Response to Planning application from Hertfordshire County Council (T and CP GDP Order 2015)

District ref: 6/2023/1422/HOUSE
HCC ref: WH/17830/2023
HCC received: 8 August 2023
Area manager: Manjinder Sehmi
Case officer: Manjinder Sehmi

52A Plough Hill Cuffley Potters Bar EN6 4DS

Installation of automated and manual swinging gates

Drawing No. J35365-PC-02

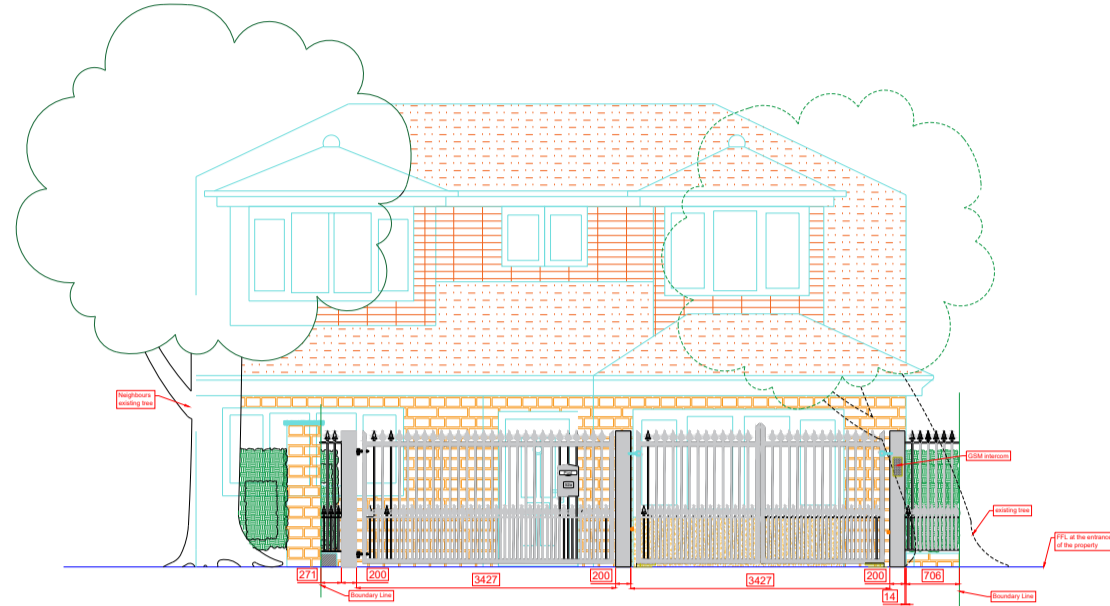
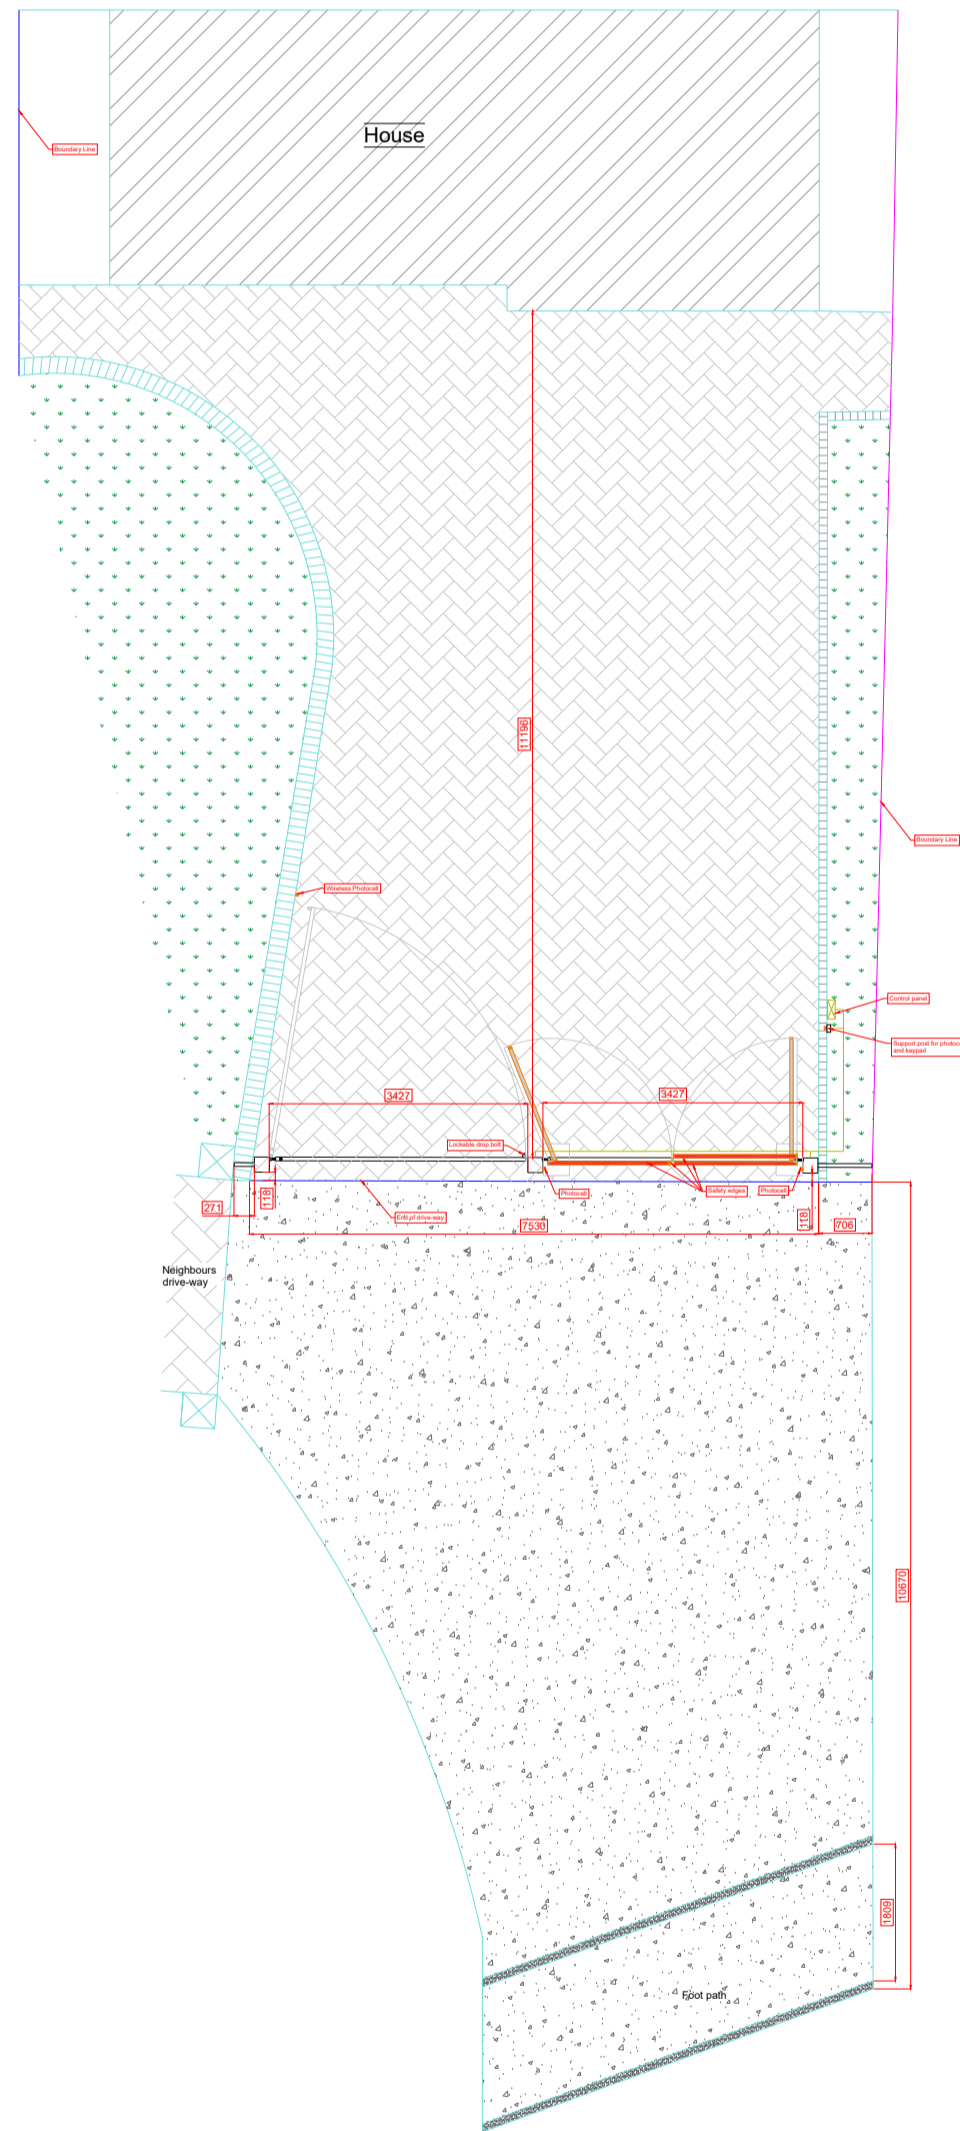
The application consists of Installing automated and manual swinging gates to the existing driveway. The proposed gates will be opening inwards into the site and will be located at a sufficient distance (approx. 9m) away from the back edge of the existing footway. There are no proposed changes to the existing access/driveway from Plough Hill (A Secondary Distributor Road), and this serves both No. 52 and the application site. There is sufficient visibility for vehicles to enter and exit the site.

In view of the above, the proposal is not considered to result in any adverse impact on the highway network and therefore the Highway Authority has no objection to the proposal.
